Our ref: DOC24/610204-6

NEXT DC S5 Data Centre Ryde (SSD-63168959) EPA Advice on EIS

Appendix A – EPA comments on EIS

**Figure 4: Typical arrangement of diesel generators and Li-ion batteries for levels 04-05 (Building A & B) – gens = pink highlight, LIBs = green highlight**

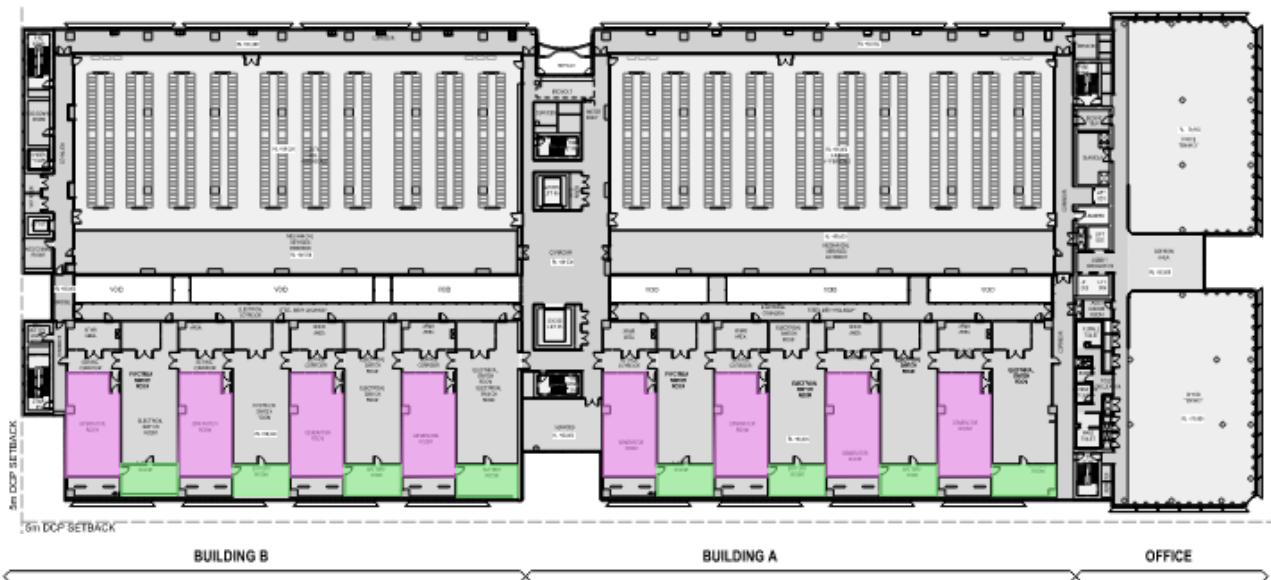
- Should the proposal be approved, a condition should be included that provides that no more than one standby generator can be undergoing routine testing at a time.
- Select equipment with sound power levels no more than values as listed in Table 16 of the NVIA.
- Plant roof screens and louvres should be incorporated as described in Figure 3 and Figure 4 of the NVIA.
- Generators should be attenuated as per the recommendations provided in Table 15 of the NVIA.
- Load banks and water-cooled chillers are to be contained within an acoustic enclosure.
- Adoption of all other noise mitigation measures provided in Table 15.

Figure 6: Level 01 arrangement of diesel fill points

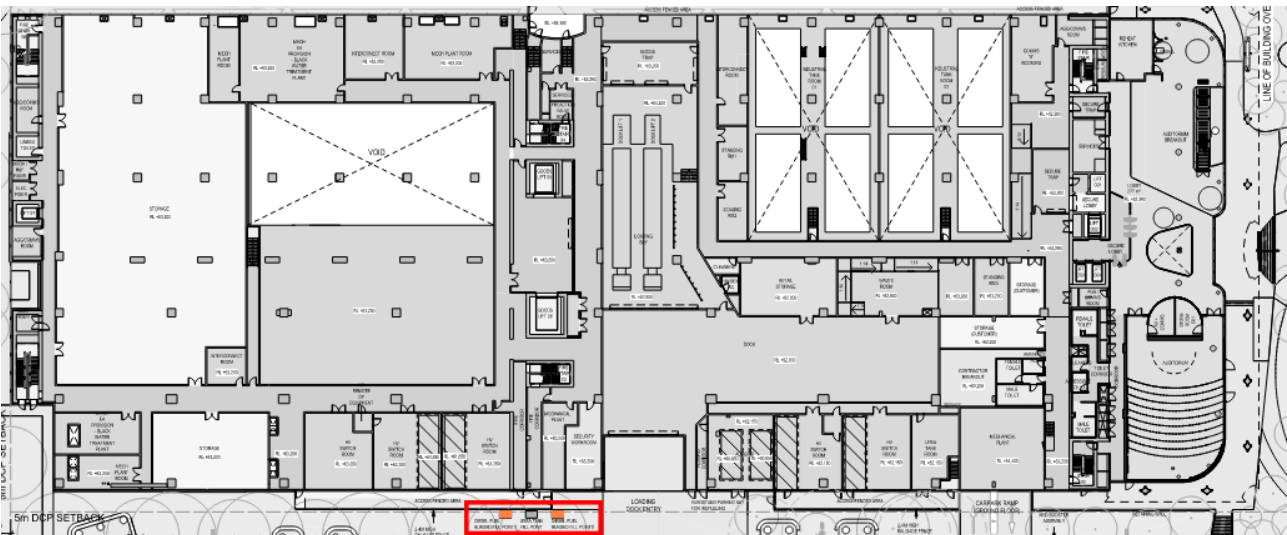
- i. Additional information on how the diesel storage tanks will be filled, including the location of the fill points, whether there is any secondary containment and/or covered and whether fill protection controls such as shut off valves and level alarms will be installed.

- ii. That tanks should be either belly (within generators) or double skinned above-ground.
- iii. Secondary containment or stormwater cut-off should be considered in the event of a spill of a belly tank.
- iv. Fuel storage, including secondary containment and fill points, must comply with AS 1940:2017.
